Written objection for SSD 17-8970 03/01/2018 St Joseph's College Hunters Hill.

Thank you for providing the opportunity to comment on the proposed development at St Joseph's College Mark Street Hunters Hill. The development is for the demolition of existing building and sports facilities and the construction of new sports courts and associated facilities.

VIEW FROM CORNER OF GLADESVILLE RD AND LUKE ST

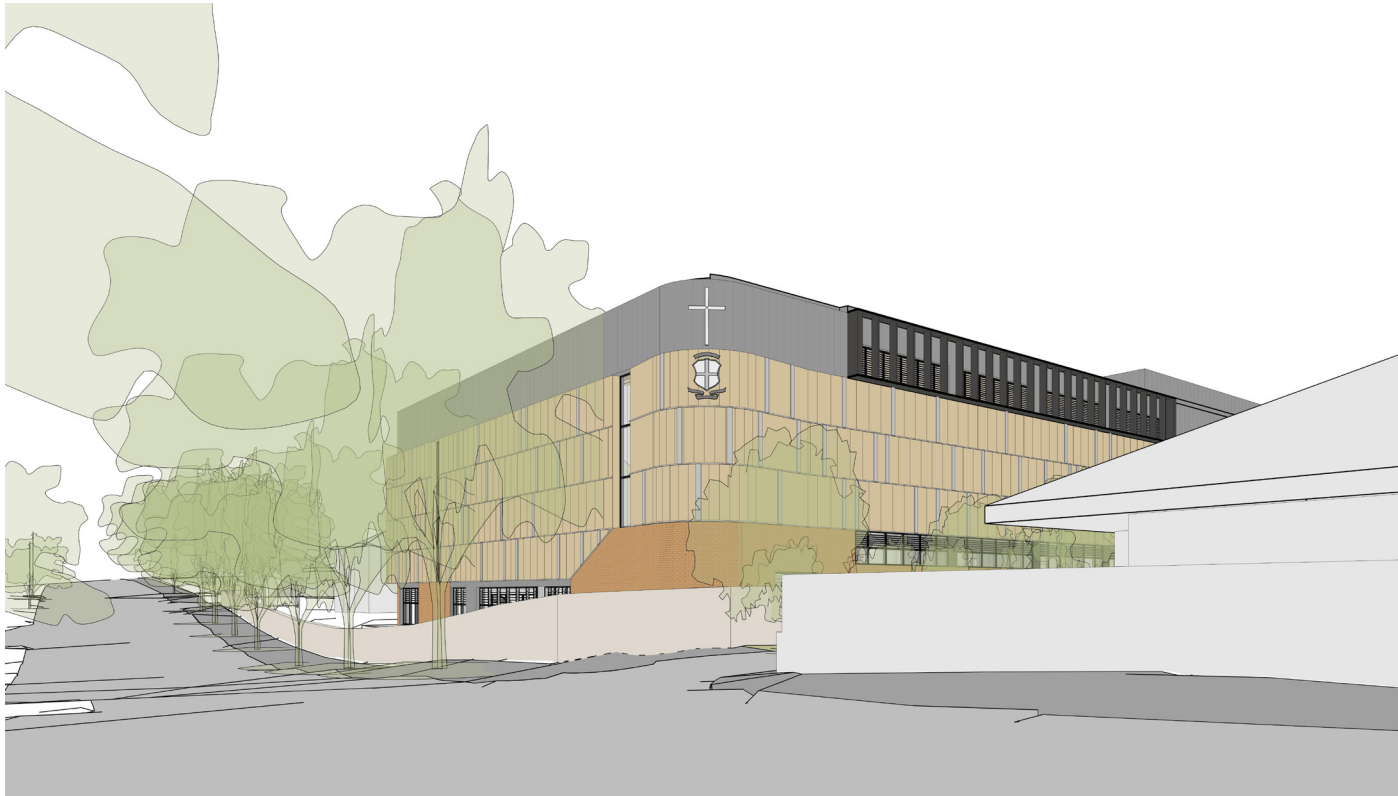
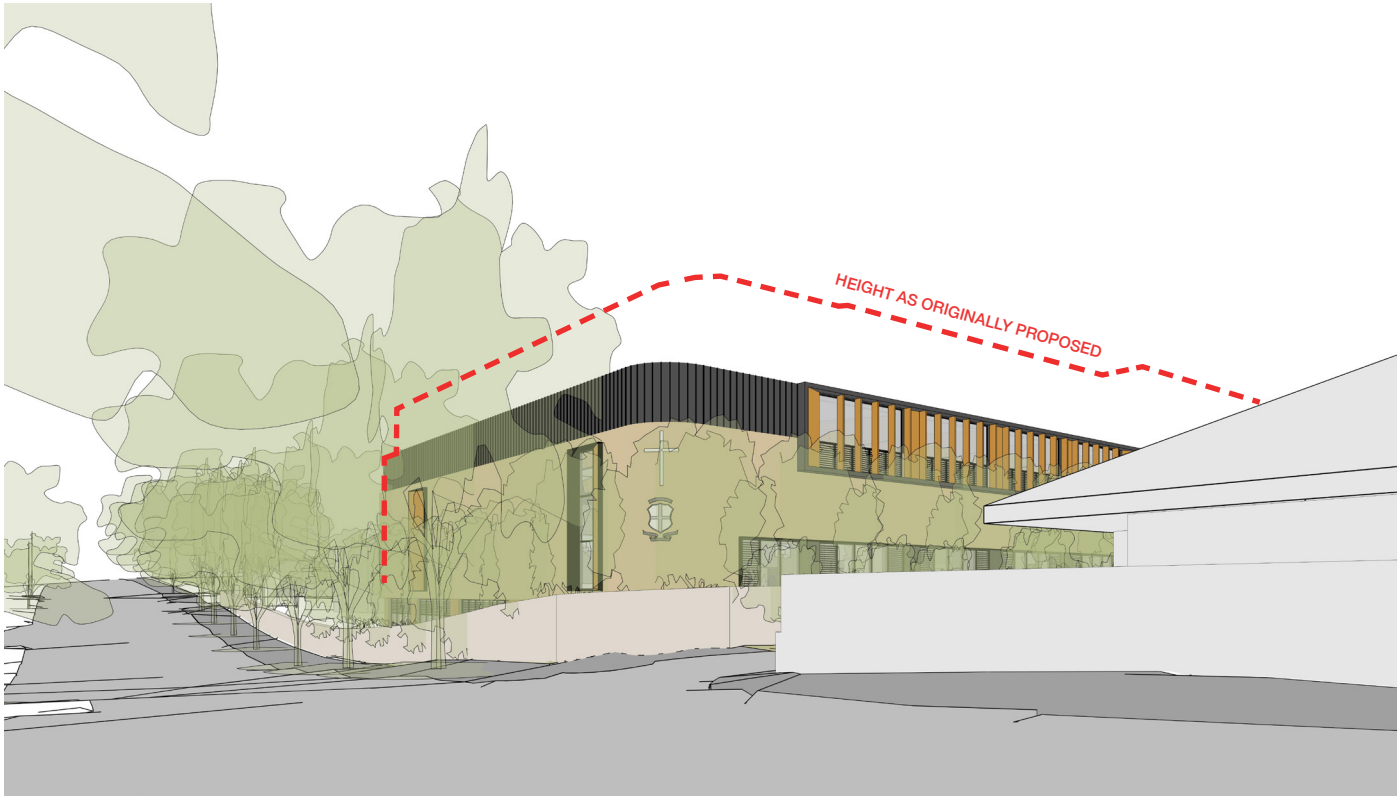
The proposed building to replace these courts will be 16m high and a modern solid structure with a larger footprint. It will become the tallest structure located along the north side of Gladesville road between Mary Street and Matthew Street. The development will be visually and physically dominant along Gladesville road and Luke Street, an area that is predominantly residential housing with street front gardens and Heritage buildings used as housing, nursing homes and aged care with extensive street front gardens.

The proposed new building is noted at 16m high at the corner of Gladesville road and along Luke Street. I believe that this height is completely incompatible with the surrounding homes.

Along Luke Street, the proposed eastern setback is only 1.3 m back from the existing heritage stone wall. Forward of all other building line along Luke Street

Along Gladesville Road, the proposed southern setback varies between 4.2 and 3.6 m from the existing heritage stone wall. Again it is significantly forward of the existing building line within the college grounds along Gladesville road.

These setbacks will result in the bulk of the building coming forward on Luke Street and Gladesville road, increasing the visual impact and shadowing created by the size and position of the structure. Document AR DA 9003A view f is deceiving as it implies that the proposed structure is set back further than the actual architectural documents.
